Your Ref: 2025/0580

Our ref: 1229

**RESIDENTIAL DEVELOPMENT ON LAND SOUTH OF DONCASTER ROAD, DARFIELD
(PLANNING REFERENCE 2025/0580)**

ORIGINATOR	PROJECT	VOL.	TYPE	ROLE	NUMBER
PRGN	1229	HGN	DR	CH	102A

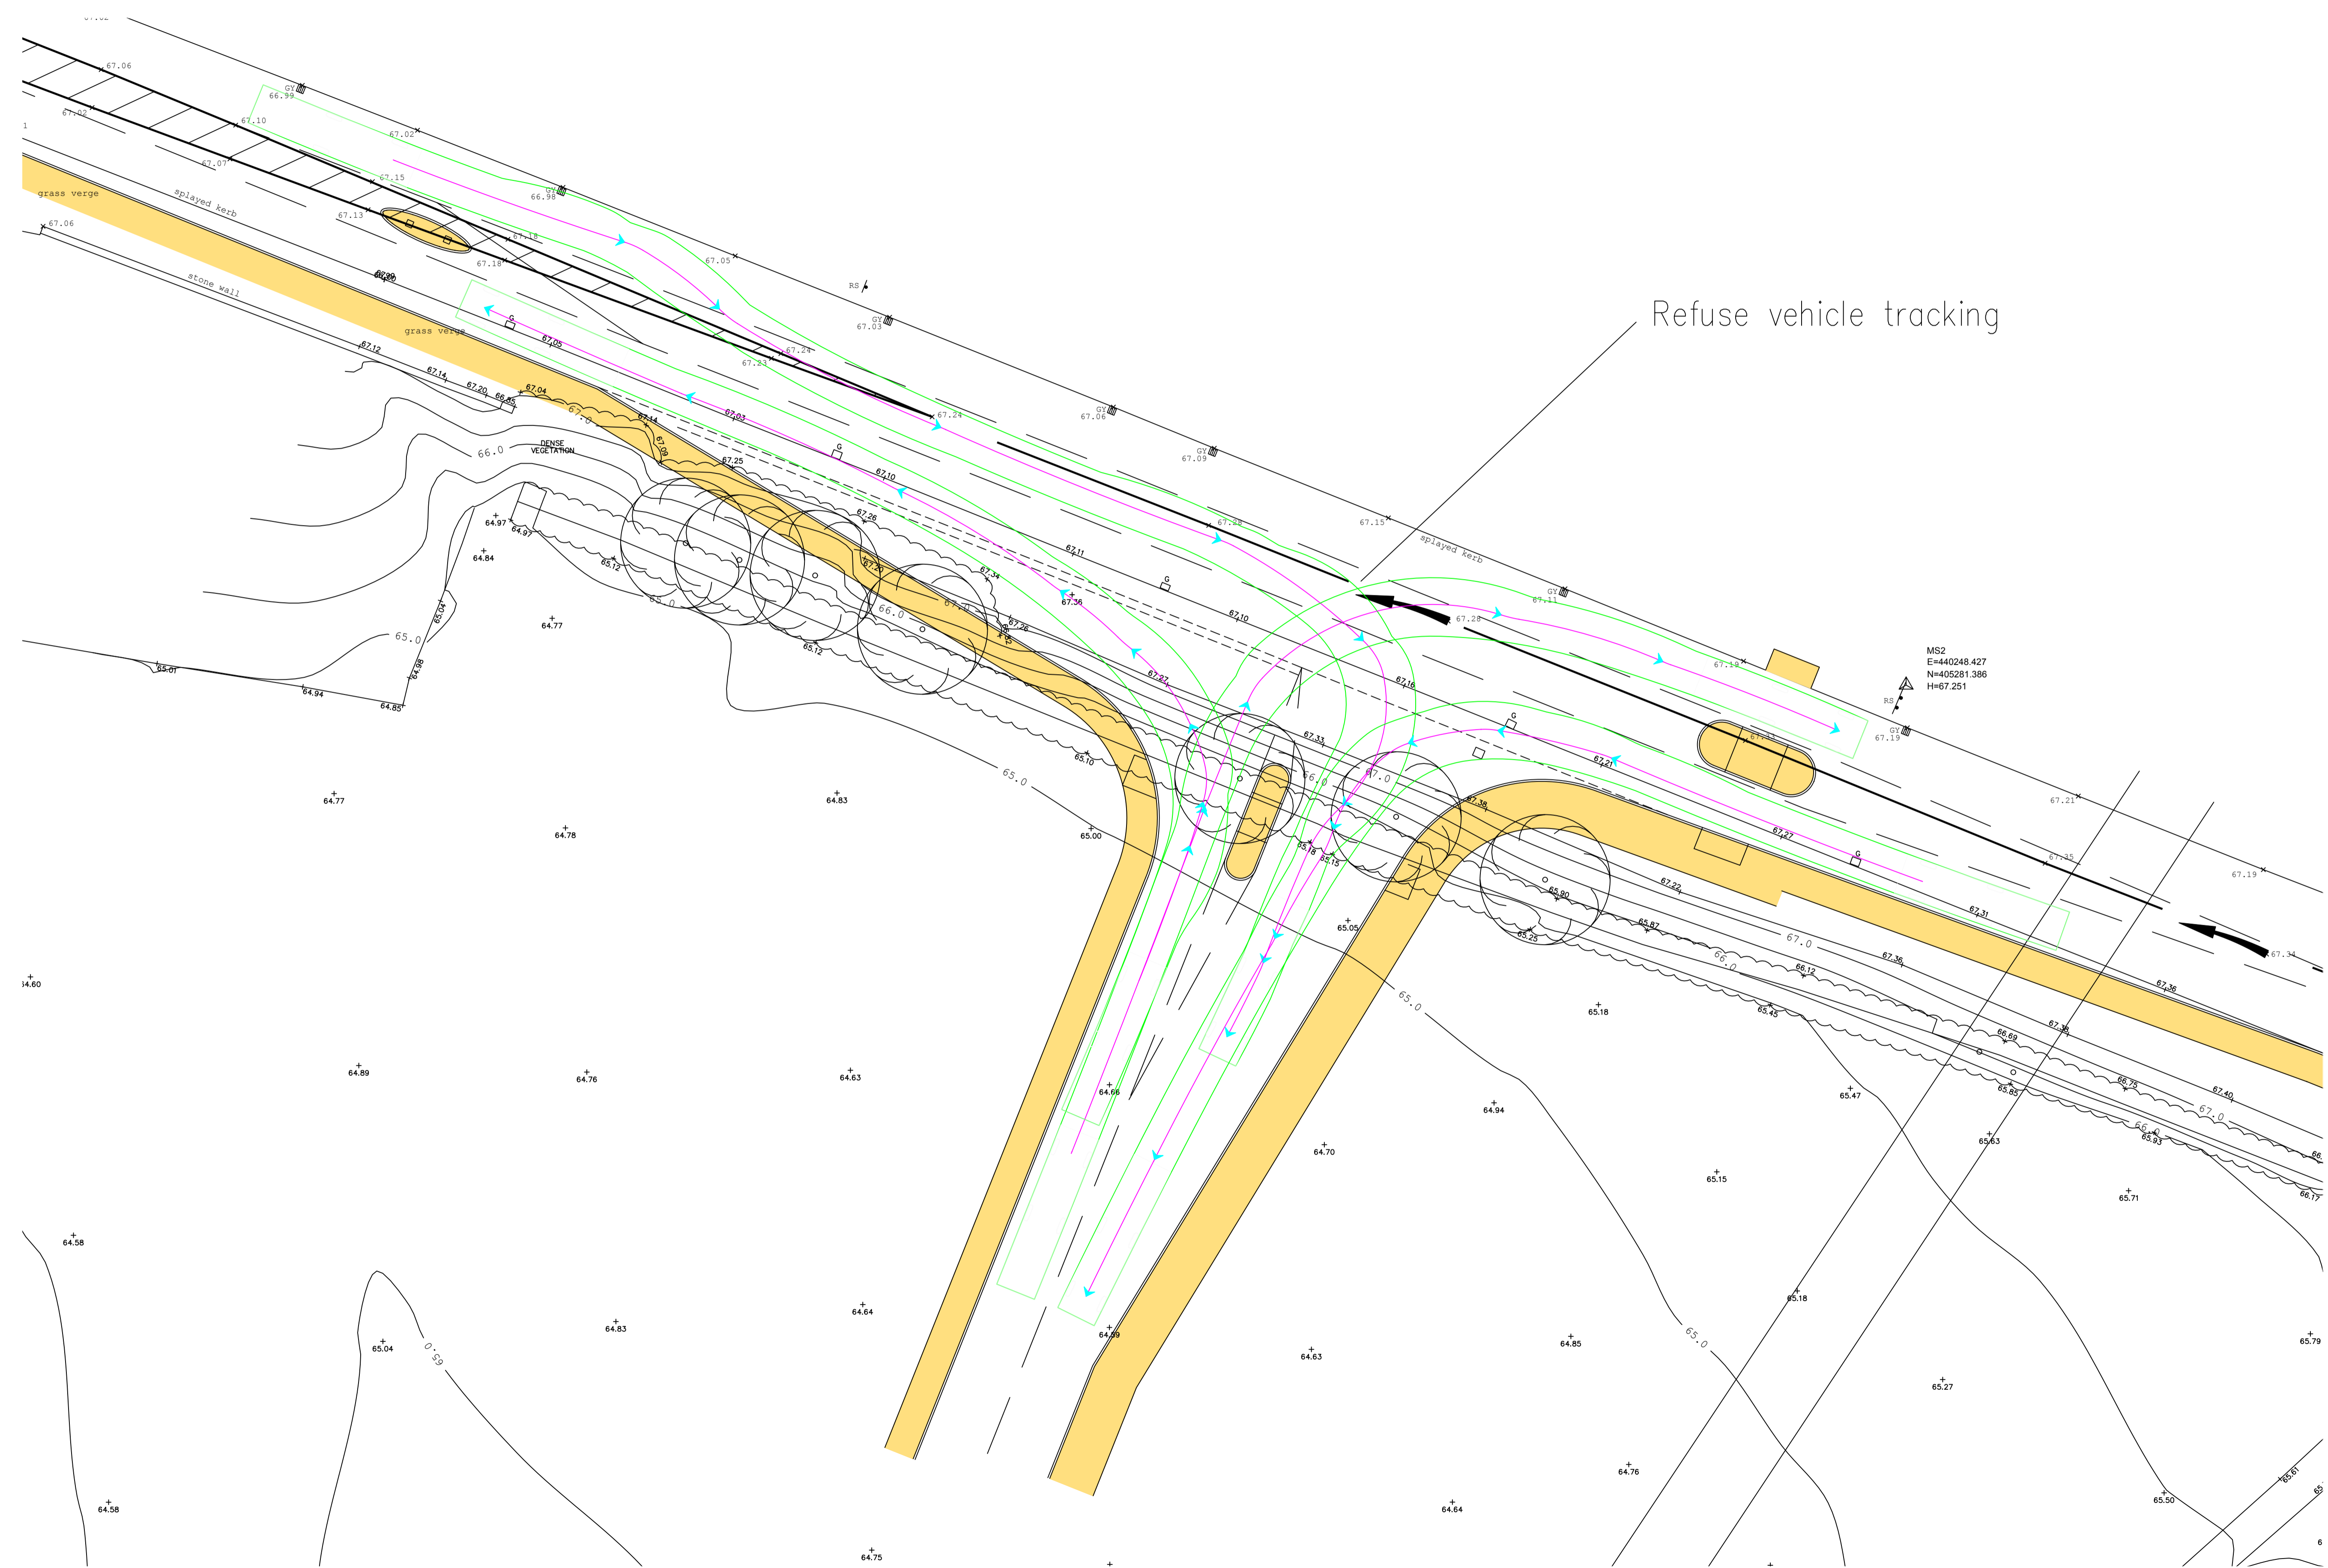
In respect to vehicle tracking drawings, the tracking drawing identifies a green outline along the track run (see image below) which includes the vehicle body. As can be seen from the tracking drawing submitted there are no instances where the body of the vehicle overhangs footways or hard margins (Please refer to PRGN-1229-HGN-DR-CH-102A & PRGN-1229-HGN-DR-CH-1002A)

ORIGINATOR	PROJECT	VOL.	TYPE	ROLE	NUMBER
PRGN	1229	HGN	DR	CH	101G

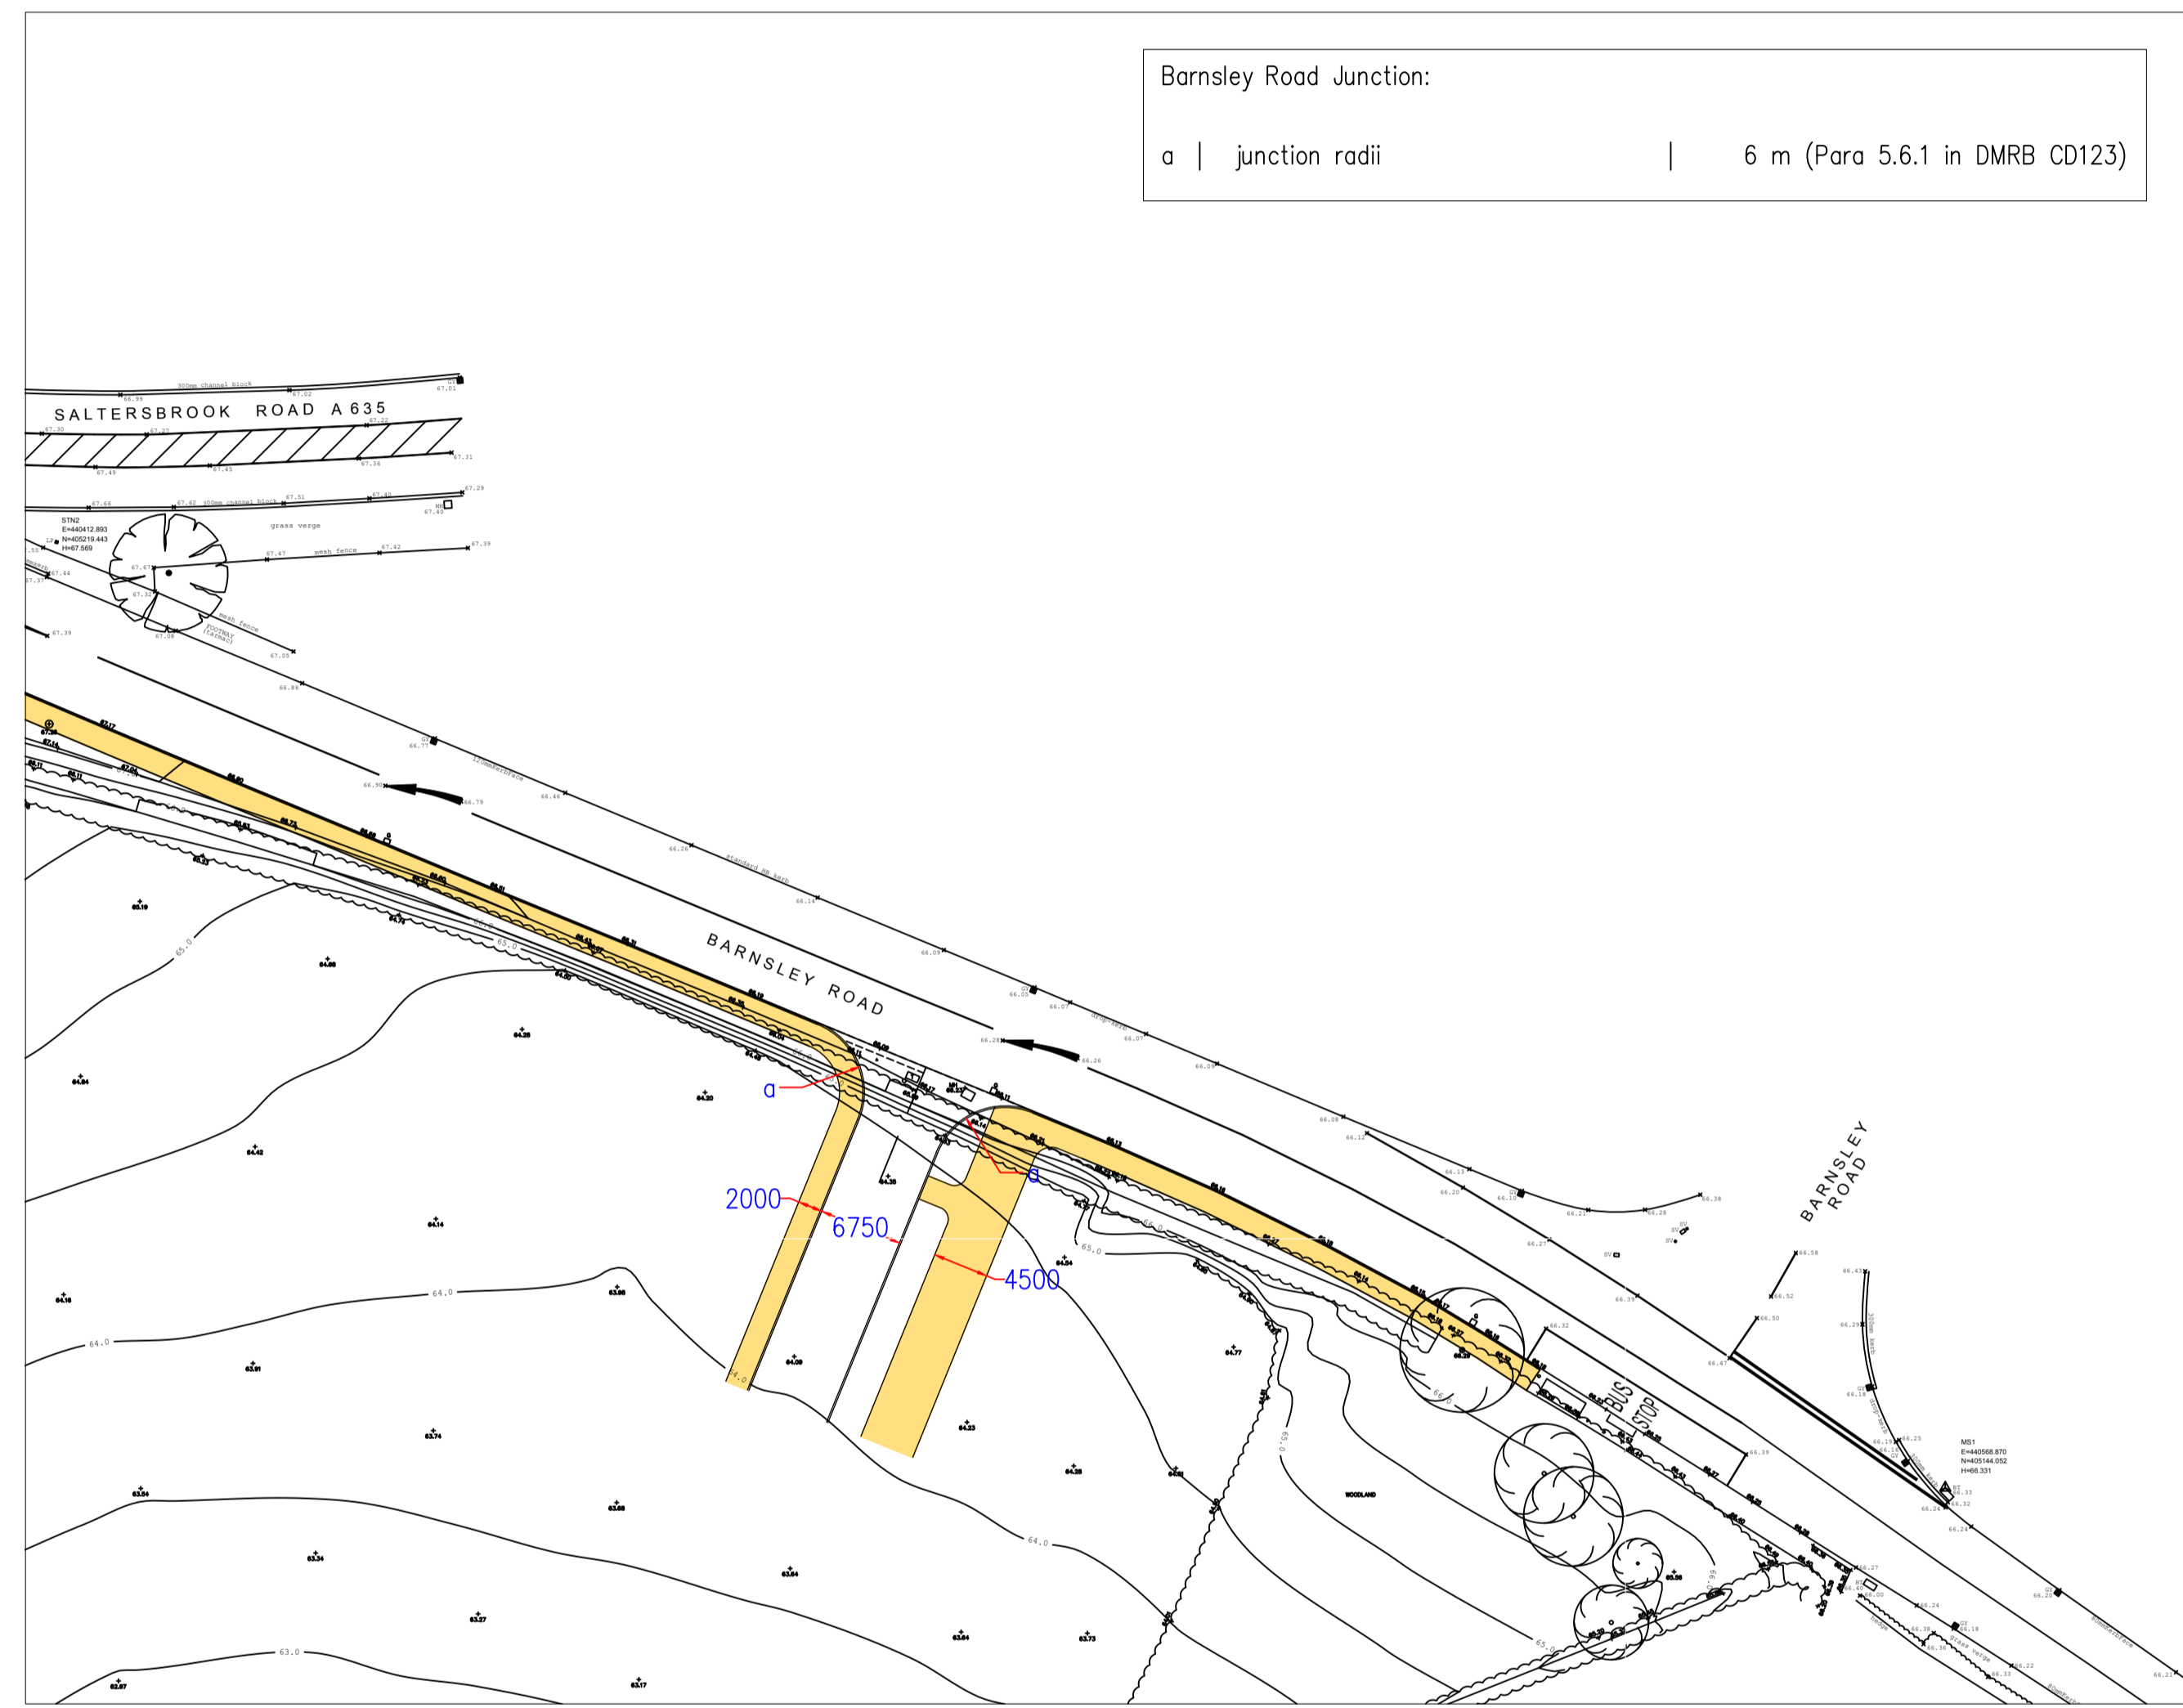
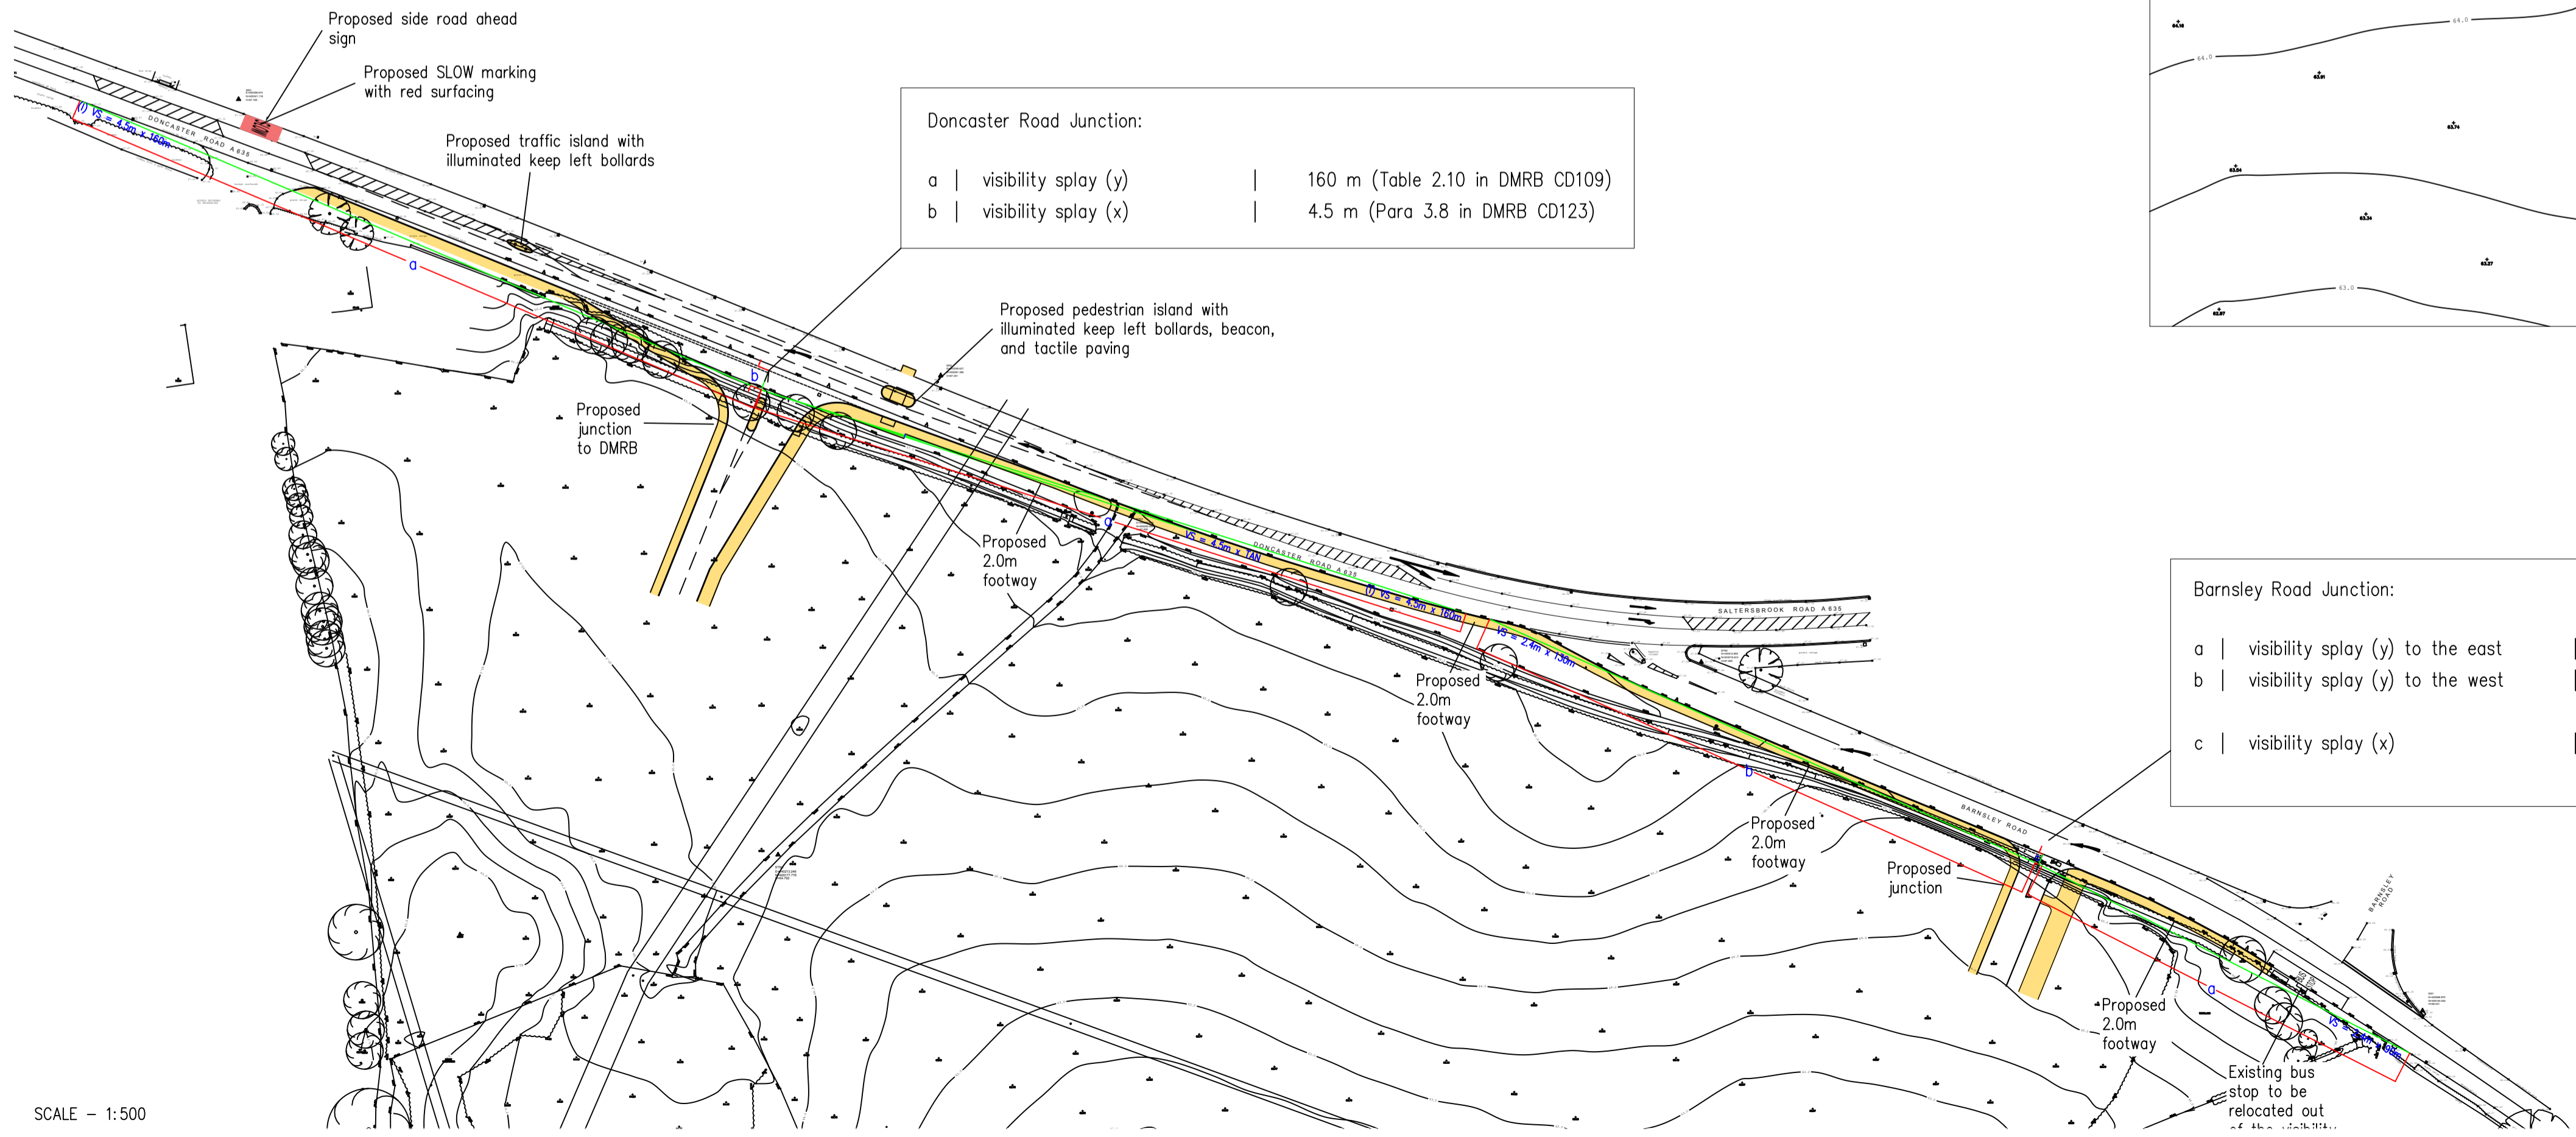
With regard to the proposed junction on Doncaster Road and in particular the junction radii, the proposed junction has been designed to Design Manual for Roads and Bridges and contains a 15m radius on both sides complete with entry and exit tapers. I understand from your response that you require a smaller radius for this junction and as a result we have changed the radius to 10m on both sides. Please see drawing PRGN-1229-HGN-DR-CH-101G & PRGN-1229-HGN-DR-CH-102A.
